PRELIMINARY/FINAL DRAINAGE REPORT

JUDGE ORR ROAD RV PARK & STORAGE DEVELOPMENT

**ADP Project No.160301
May 1, 2019**

PCD Project #PPR-16-040

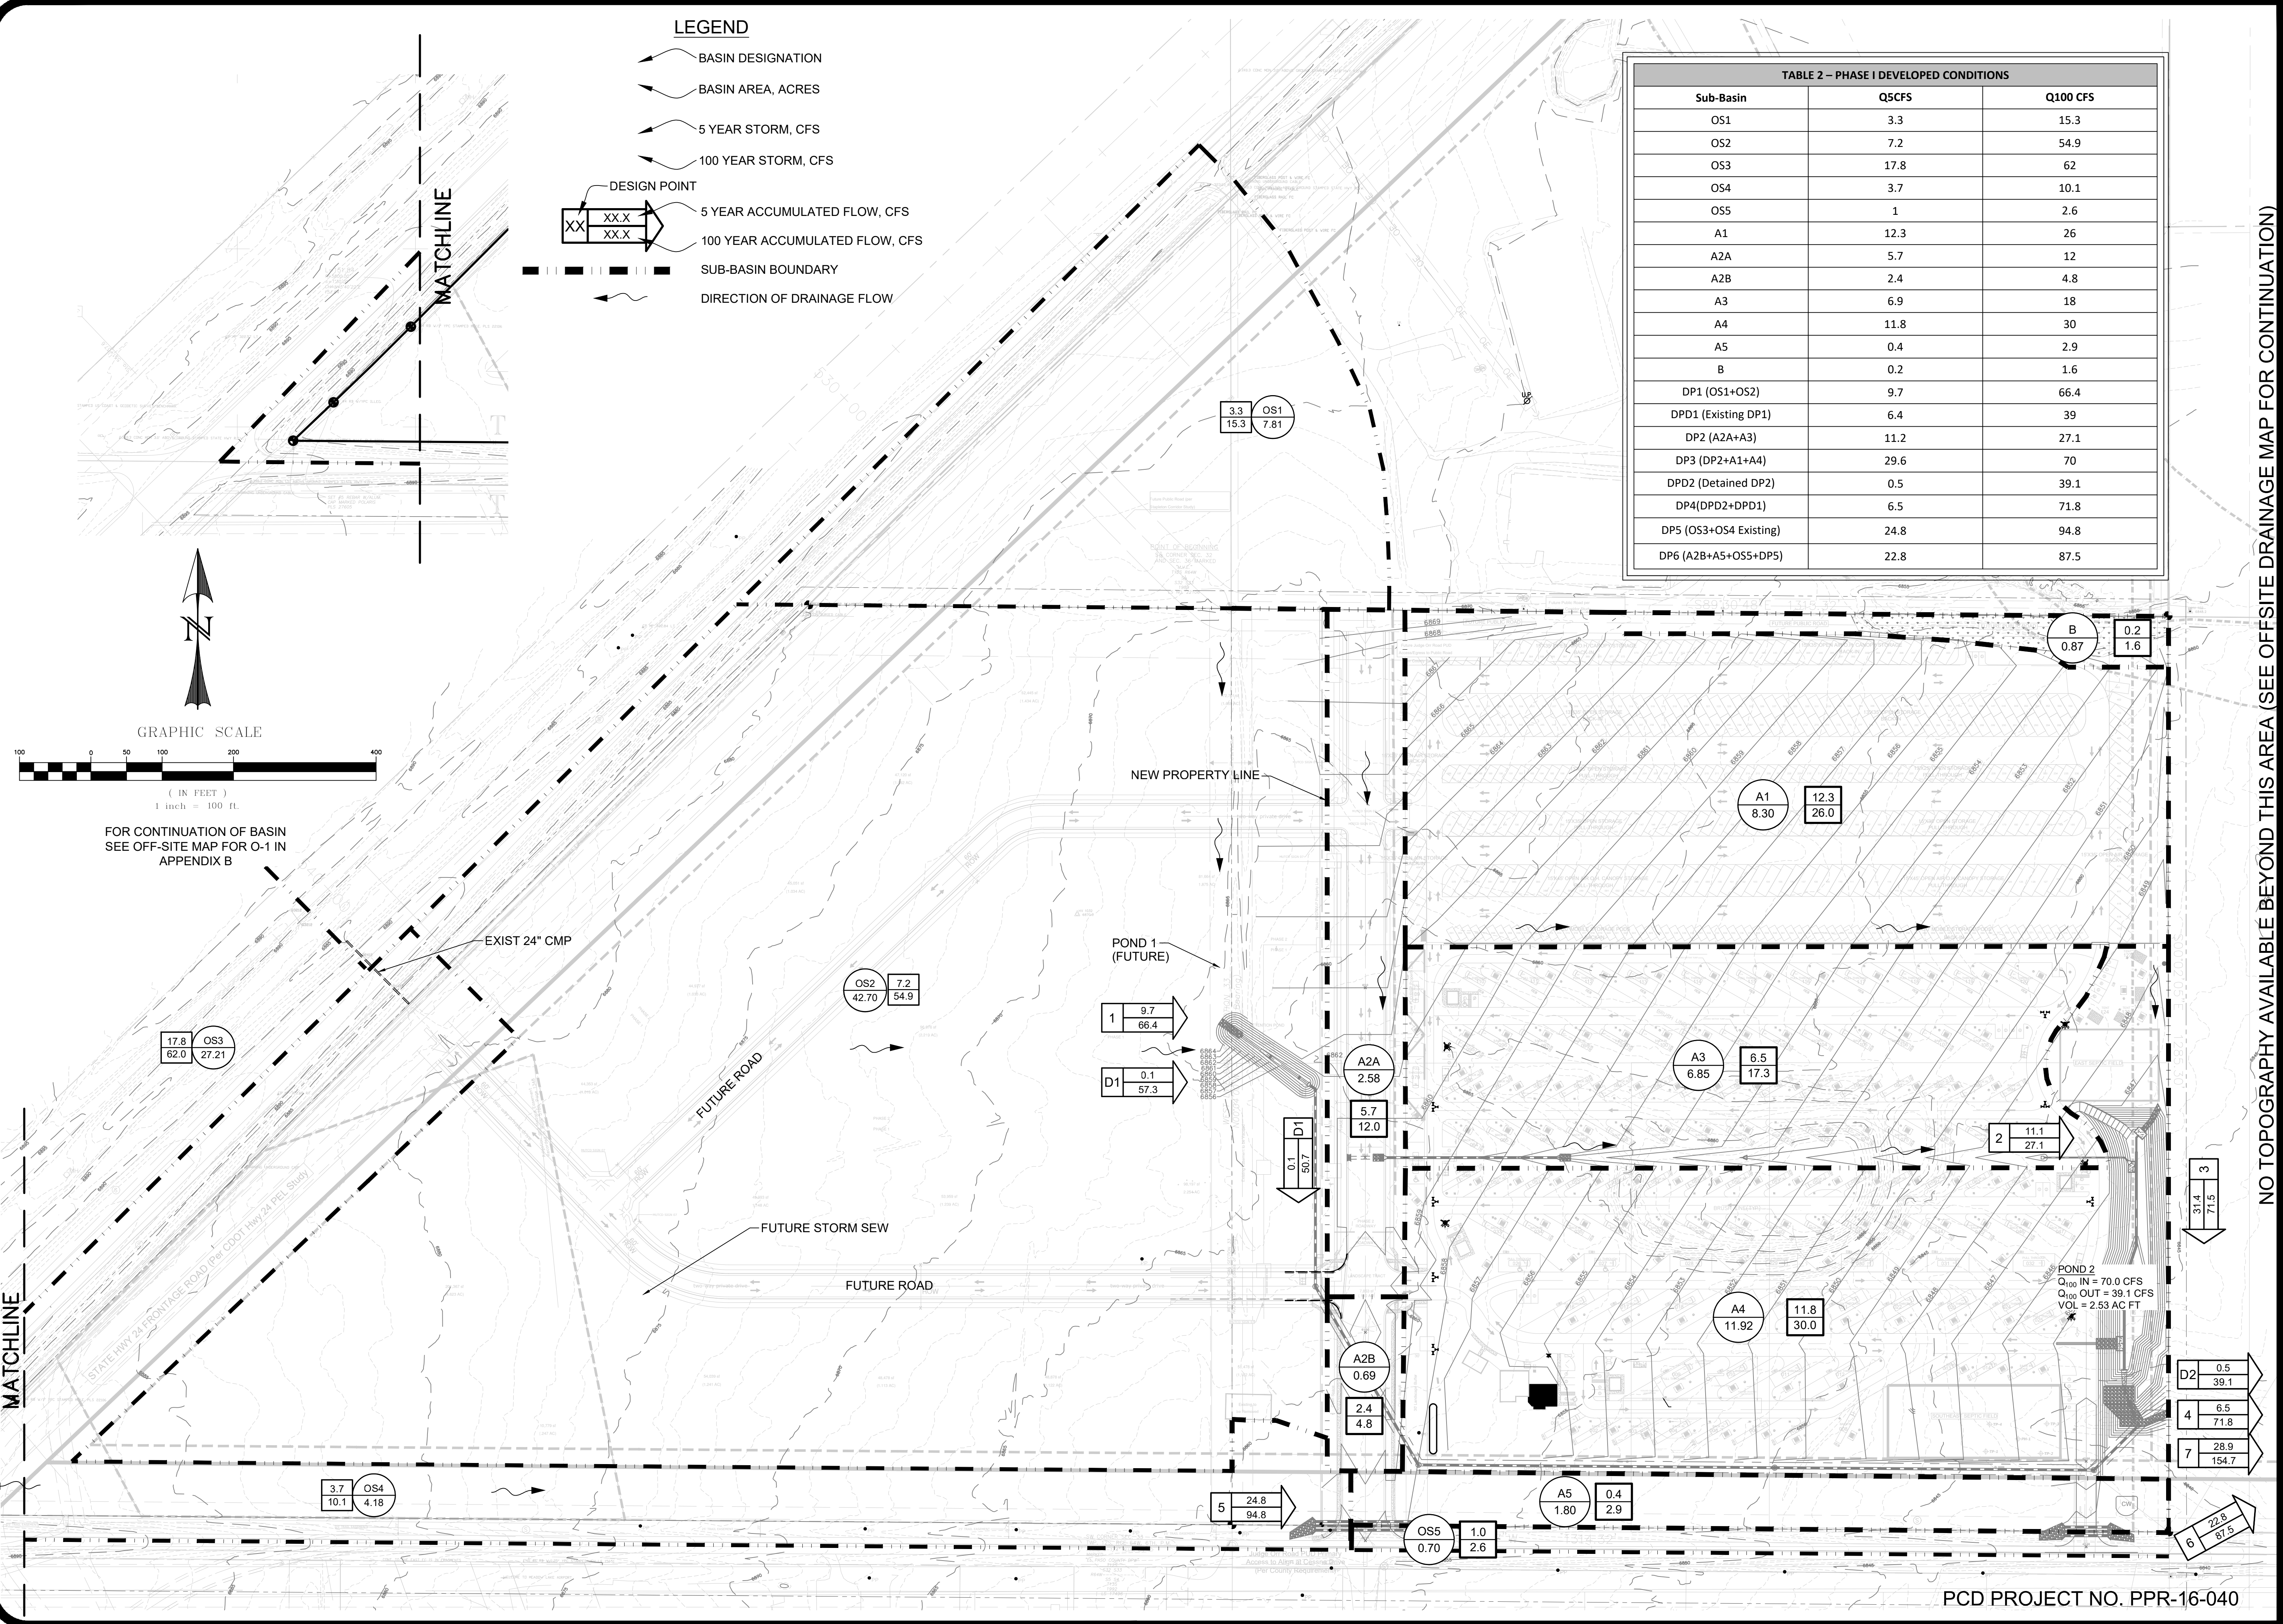
Does not match the drainage map
